**Subject:** Rezoning Petition Review

**Date of Review:** July 28, 2022 (*Revised September 16, 2022*)

**Rezoning Petition #:** 22-030

**Location of Property:** Approximately 0.36 acres located at the southeast intersection of Matheson Ave and Pinkney Ave, west of Clemson Ave.

800 MATHESON AVE - REZONING
 PARCEL ID 0811127
 800 MATHESON AV CHARLOTTE NC 28205
SITE PLAN - REZONING

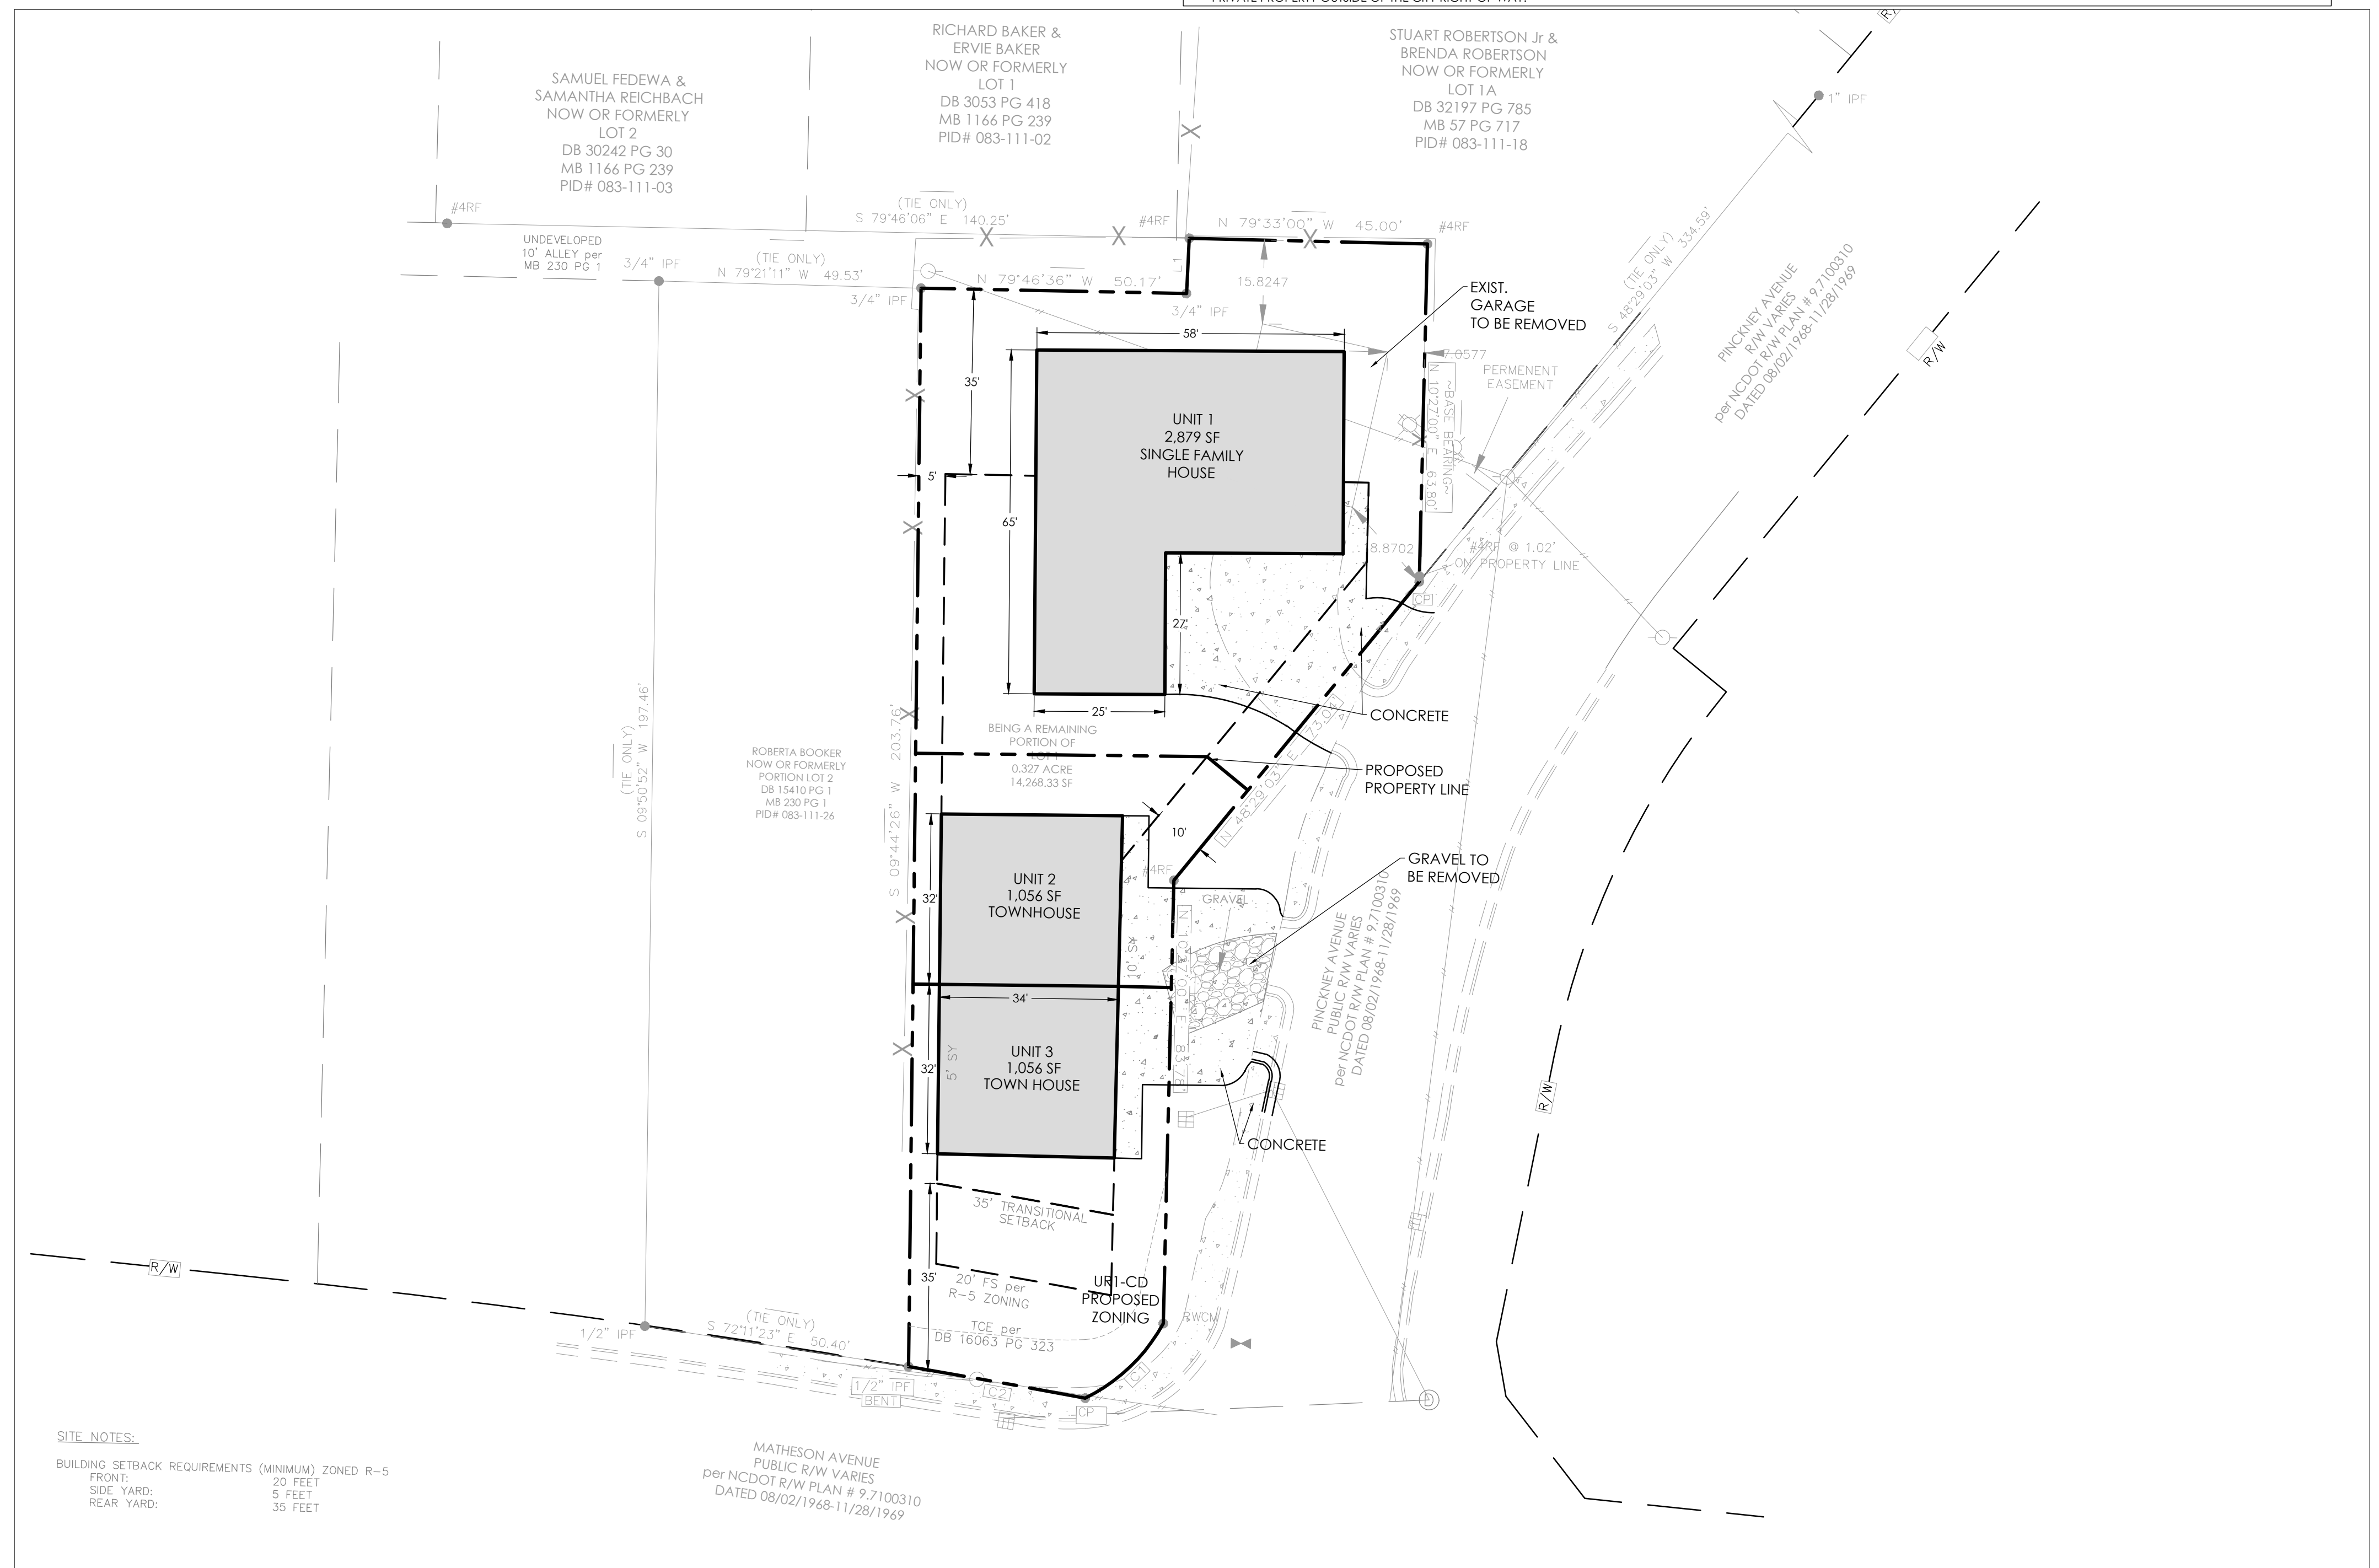
**This property drains to Upper Little Sugar Creek, which is an impaired/degraded stream, and may contribute to downstream flooding. This project has the opportunity to mitigate future impacts to this stream, therefore, Storm Water recommends placing the following notes on the plan:**

(I) Storm Water Quality Treatment

For defined watersheds greater than 24% built-upon area (BUA), construct water quality stormwater control measures (SCMs) designed for the runoff generated from the first 1-inch of rainfall for all new and redeveloped BUA associated with the project. SCMs must be designed and constructed in accordance with the Charlotte-Mecklenburg BMP Design Manual.

(II) Volume and Peak Control

For defined watersheds greater than 24% built-upon area, control the entire volume for the 1-year, 24-hour storm for all new and redeveloped BUA associated with the project. Runoff volume drawdown time shall be in accordance with the Charlotte-Mecklenburg BMP Design Manual.

For commercial projects with greater than 24% BUA, control the peak to not exceed the predevelopment runoff rates for the 10-yr, 6-hr storm and perform a downstream flood analysis to determine whether additional peak control is needed and if so, for what level of storm frequency, or if a downstream analysis is not performed, control the peak for the 10-yr and 25-yr, 6-hour storms.

For residential projects with greater than 24% BUA, control the peak to not exceed the predevelopment runoff rates for the 10-year and 25-year, 6-hour storms or perform a downstream analysis to determine whether peak control is needed, and if so, for what level of storm frequency.

800 MATHESON AVE - REZONING
 PARCEL ID 0811127
 800 MATHESON AV CHARLOTTE NC 28205
SITE PLAN - REZONING 2022-030

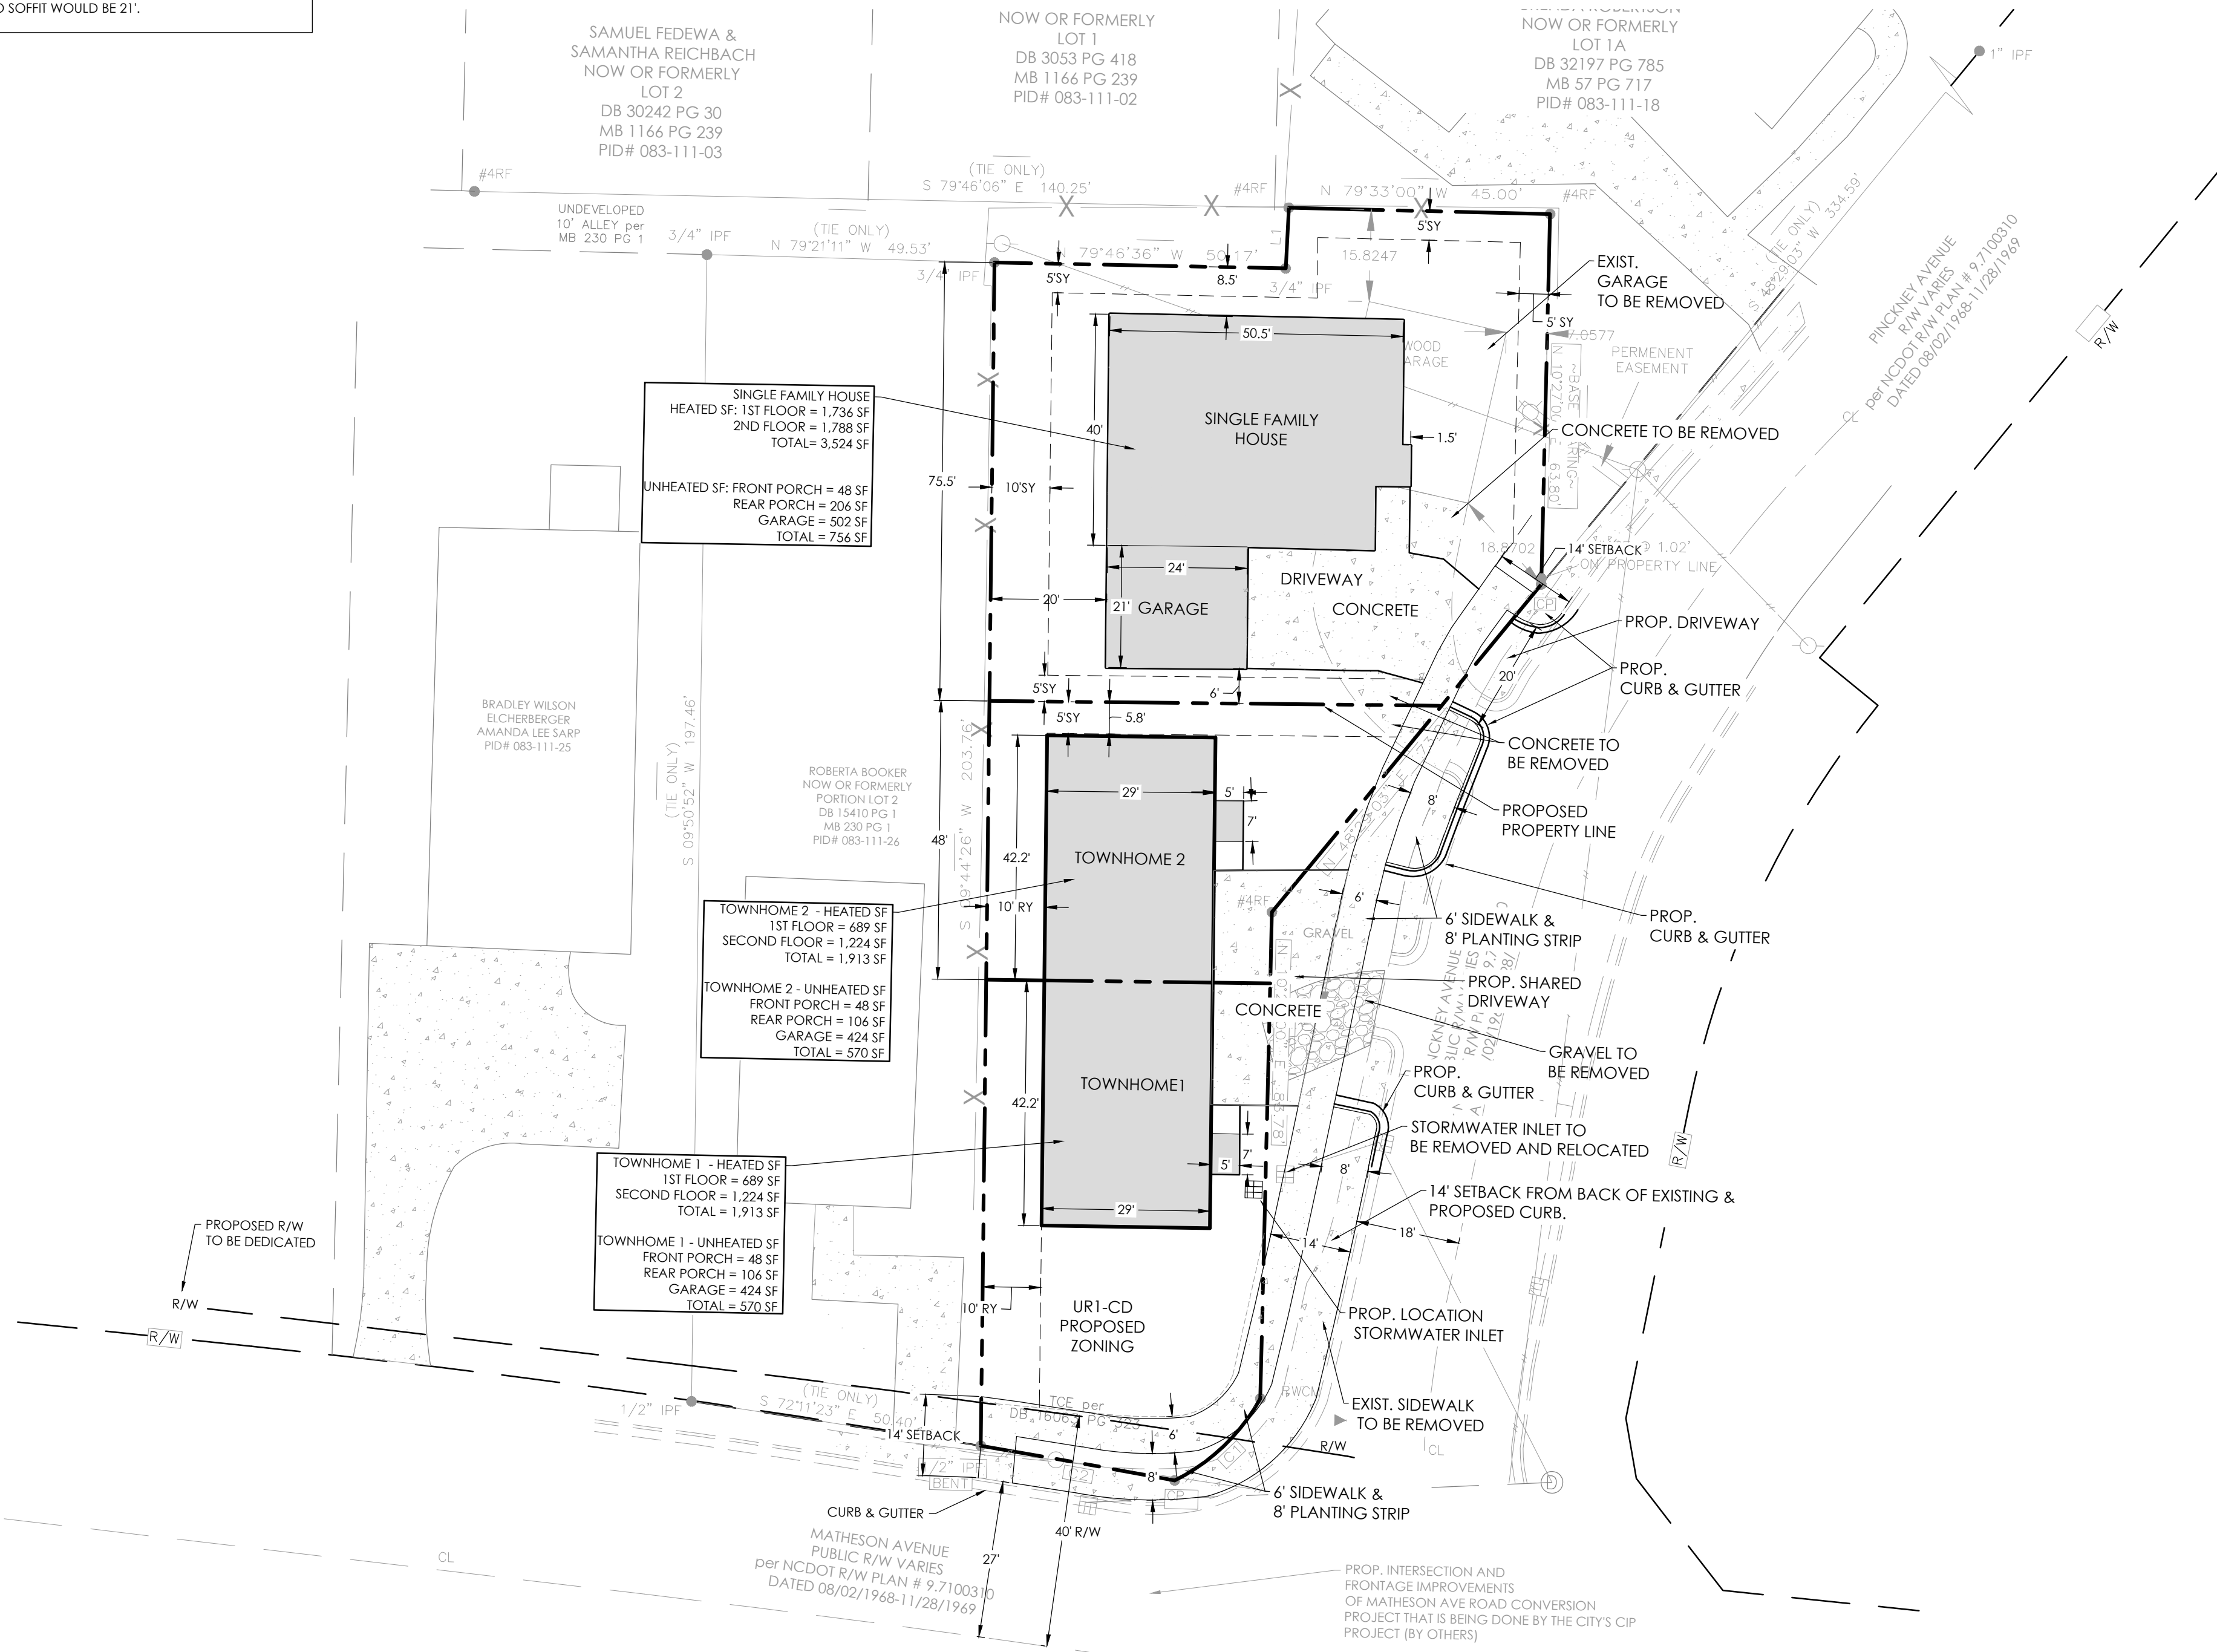
***Due to revisions (9/16/22):*** No additional recommendations are needed at this time.
